BCA Assessment Report

Billbergia - 40 Walker Street, Rhodes

Prepared for Billbergia Developments Pty Ltd

11 November 2010

1 ELEVATION
BLDG E - NORTH
1:200

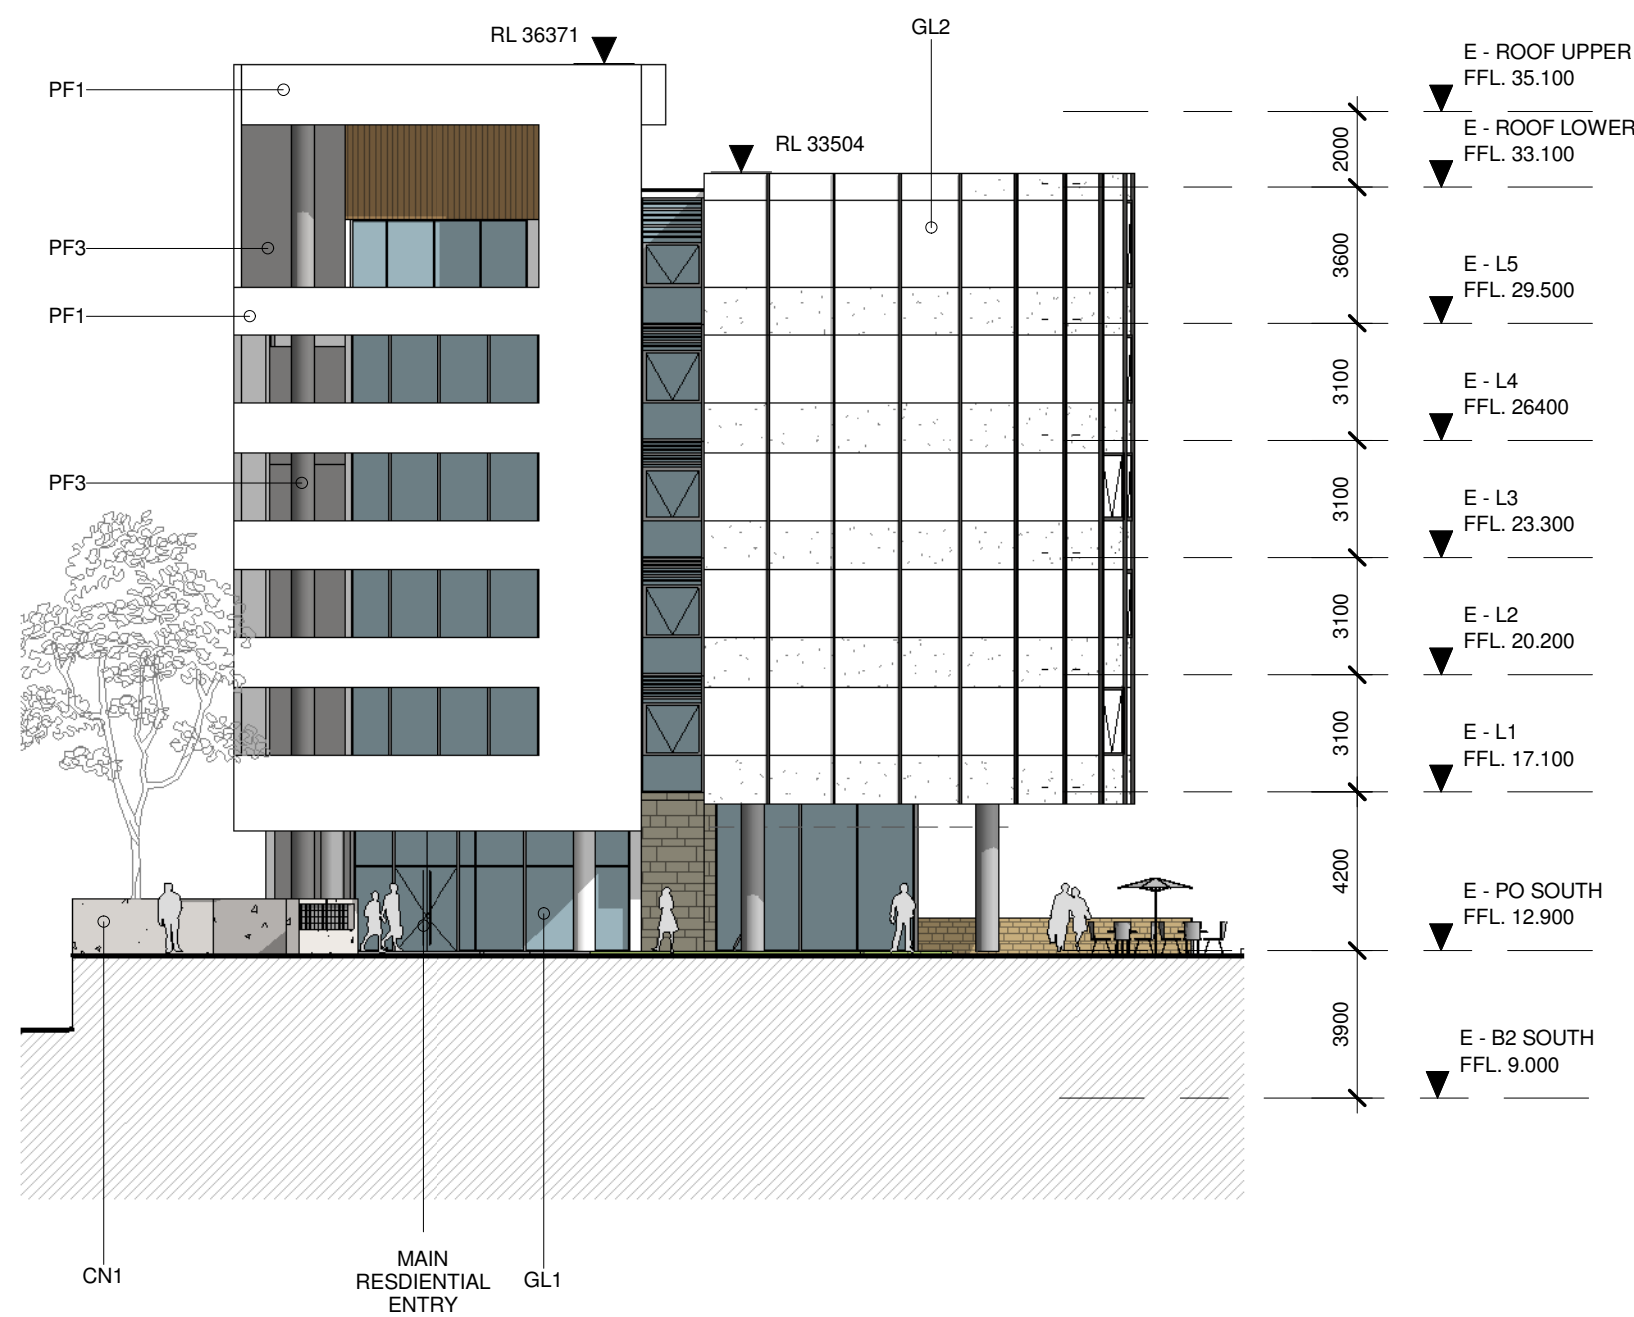
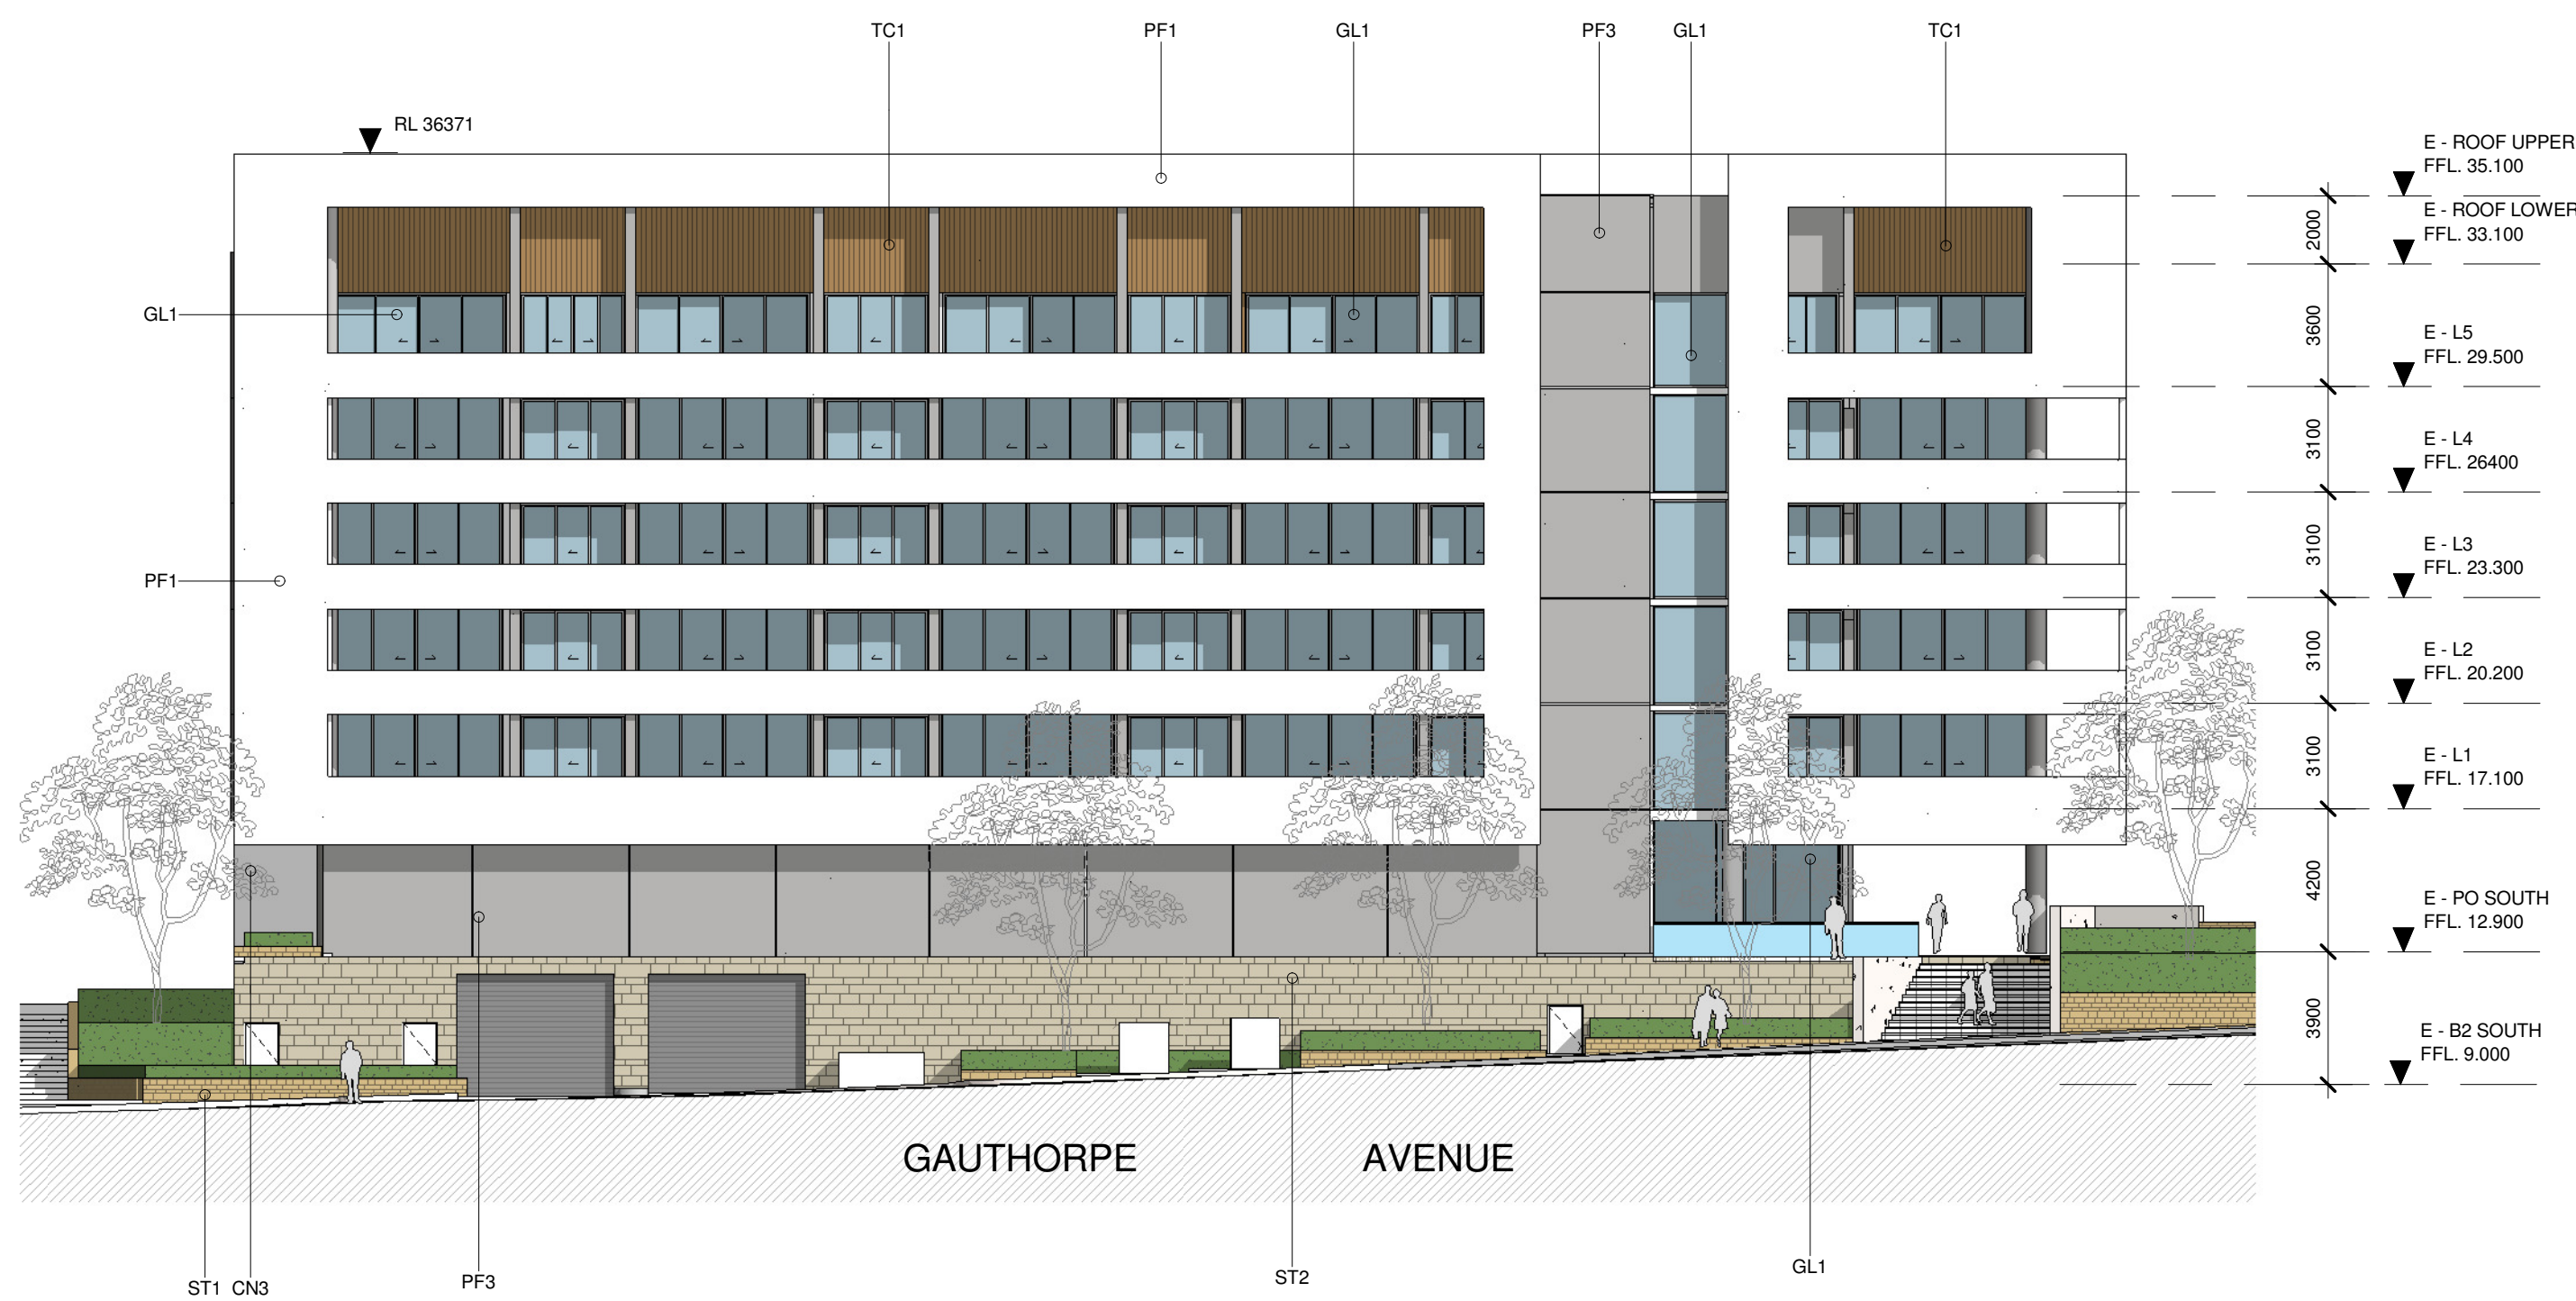
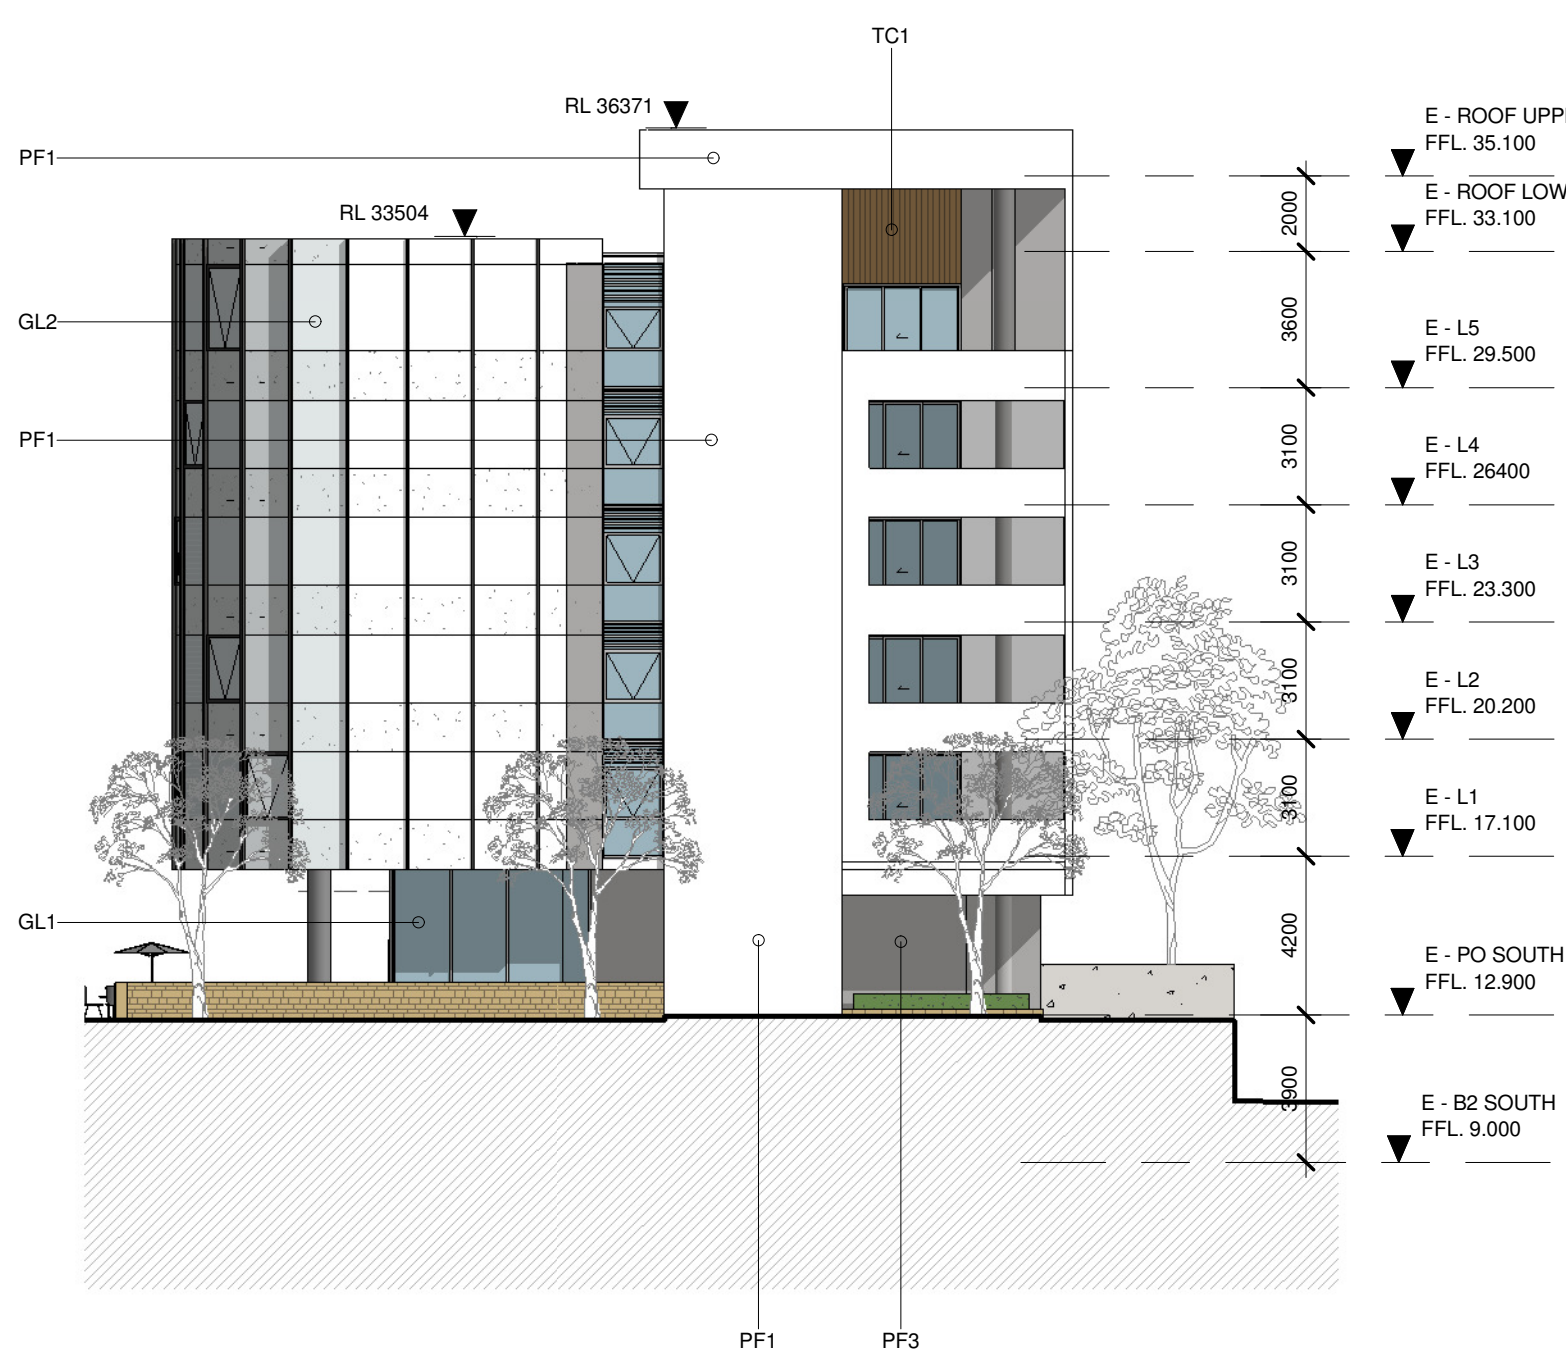
Where corridors within the new building are more than 40-metres in length smoke doors will be provided to separate the corridors, with these doors and walls provided as per specification C2.5.

- E.g. towers A and E.

The provision of smoke doors will be required in order to achieve compliance with the above requirement.
